Appeal Ref: APP/R5510/W/25/3371435

18-20 Wilmar Close, Hayes, Middlesex UB4 8ET

- The appeal is made under section 78 of the Town and Country Planning Act 1990 (as amended) against a refusal to grant planning permission.
- The appeal is made by Mr Suty Bharrich against the decision of the Council of the London Borough of Hillingdon.
- The application Ref is 67410/APP/2024/2641.
- The development proposed is 'Change of use of 2no. outbuildings to granny annexes'.

DWG#:- S/18+20/A-4

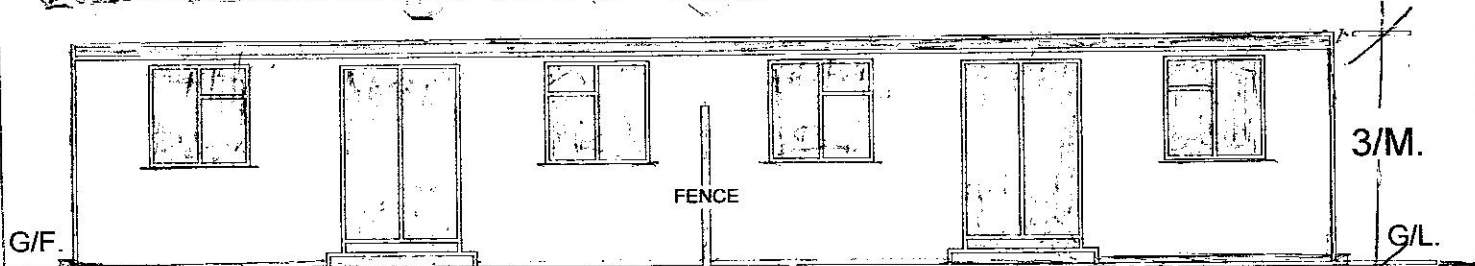
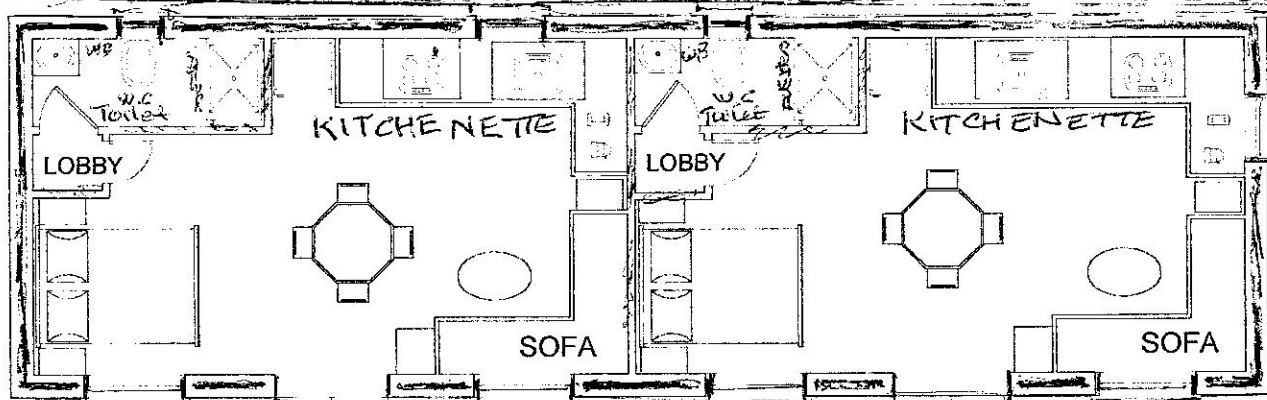
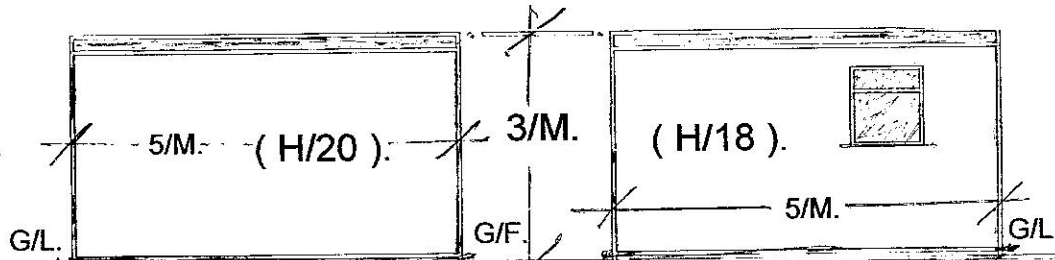
4. The proposed plan¹ is marked 'retrospective'. This statement contradicts the application form which states that the development has not begun. I saw at my site visit that a single building has been constructed within the gardens of 18-20 Wilmar Close, sited so that its centre roughly straddles the common boundary. The exterior is largely complete. However, I observed no furniture or interior fittings.

5. The plan also shows alterations to the windows fitted to this structure, which I observed had already been carried out. The Council raises no objection to this element of the scheme and I see no reason to disagree with that conclusion. As the proposal has not been completed in full, I have considered the appeal based on the proposed plan.

11. However, in terms of physical arrangements, side entrances to the rear gardens at each of the houses would permit unimpeded street access to both annexes. The outbuildings are set some distance away from the rear of the houses. The plans show the proposed annexes would each feature a bathroom with a WC and shower, a kitchenette, an open plan living area and a double bed. Therefore, the layout would include primary living accommodation, and each annexe would provide the basic facilities required for day-to-day private living despite a relatively constrained layout. Whilst it is contended the internal floor area would be below the minimum set out in the Nationally Described Space Standard, there is no substantive evidence before me which suggests meeting those standards would be a pre-requisite for a building to be described as a dwelling.

12. No details of the layout of the houses and facilities they each provide are before me. Therefore, I am unable to determine whether the facilities proposed within each annexe are proportionate in their extent and scale compared to the main houses. Nonetheless, the proposed kitchenette facilities are likely to be disproportionate as the appellant has stated that main meals would not be prepared within the annexes.
